WOODBIDGE TOWN COUNCIL ORAL PRESENTATION

ISH (3) – TRAFFIC AND TRANSPORT

Thursday 8th July 2021

Questions asked by the Locum Deputy Town Clerk of Woodbridge Town Council, Mr Gordon Musset;

TRAFFIC INCIDENT MANAGEMENT  
AREA

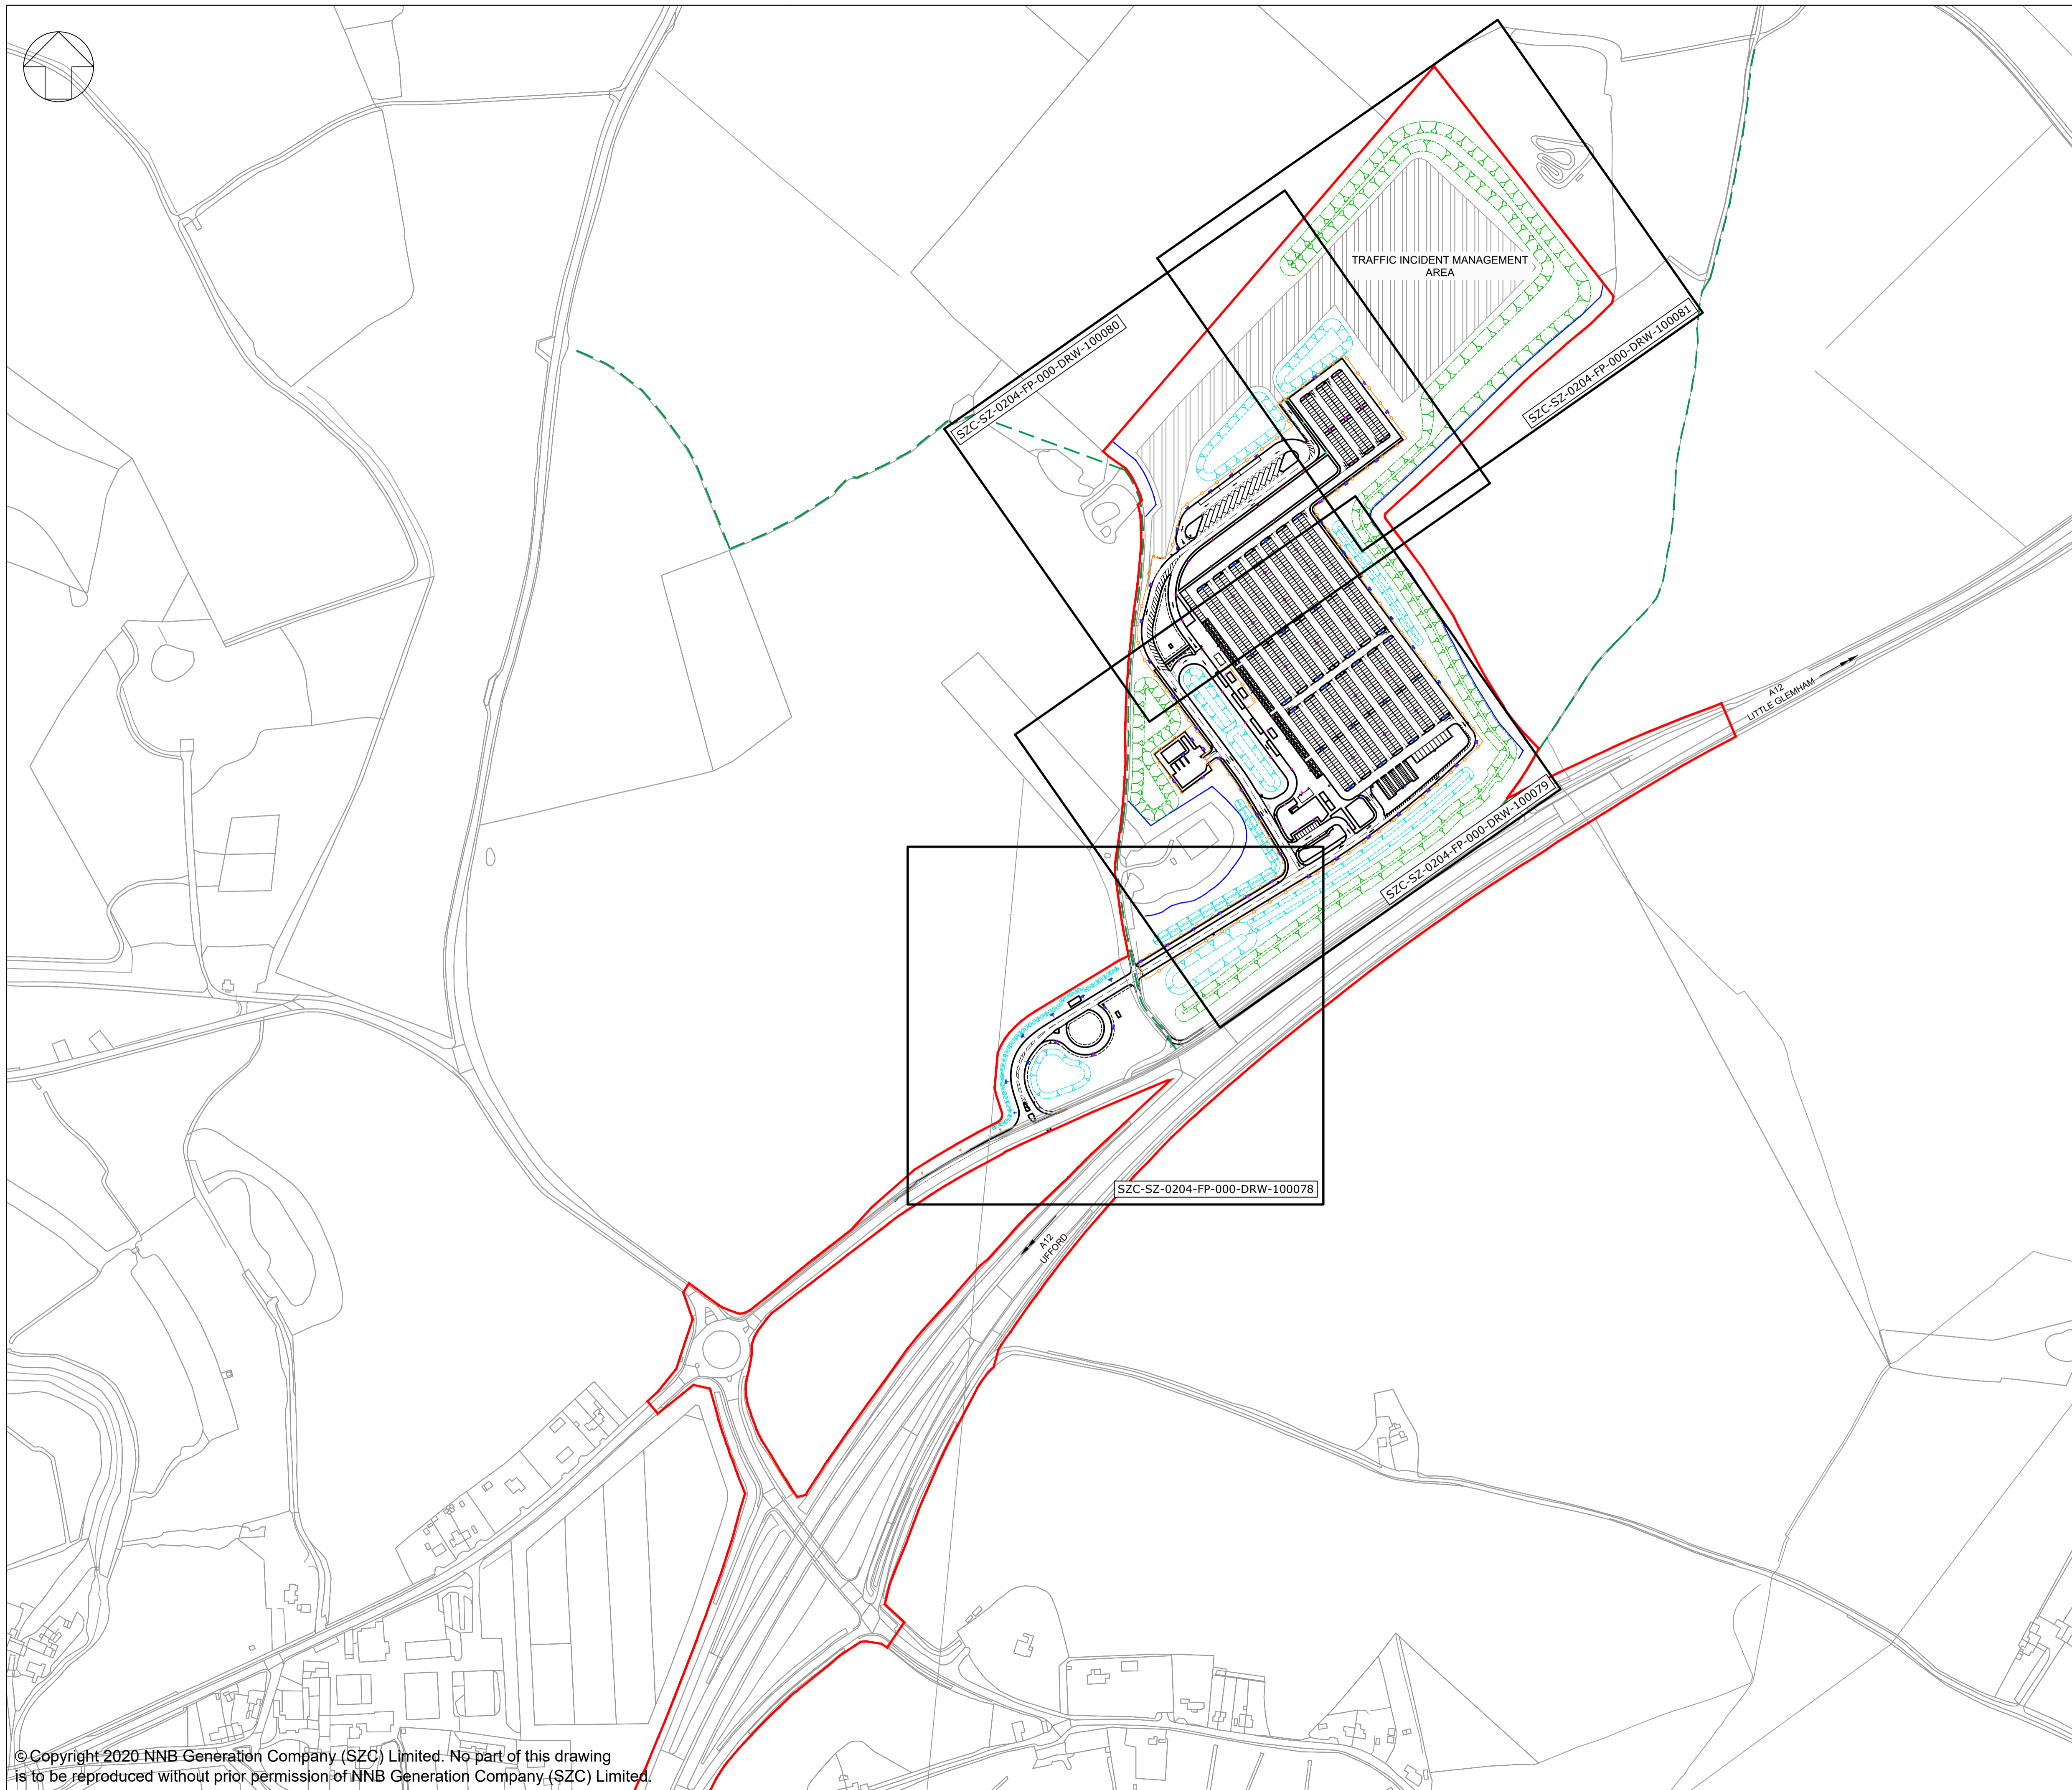
Can the applicant just confirm that the holding area for the 100 HGVs in the event of there being an accident on the A12, to be provided at Wickham Market, is a completely separate but adjoining area to the park and ride?
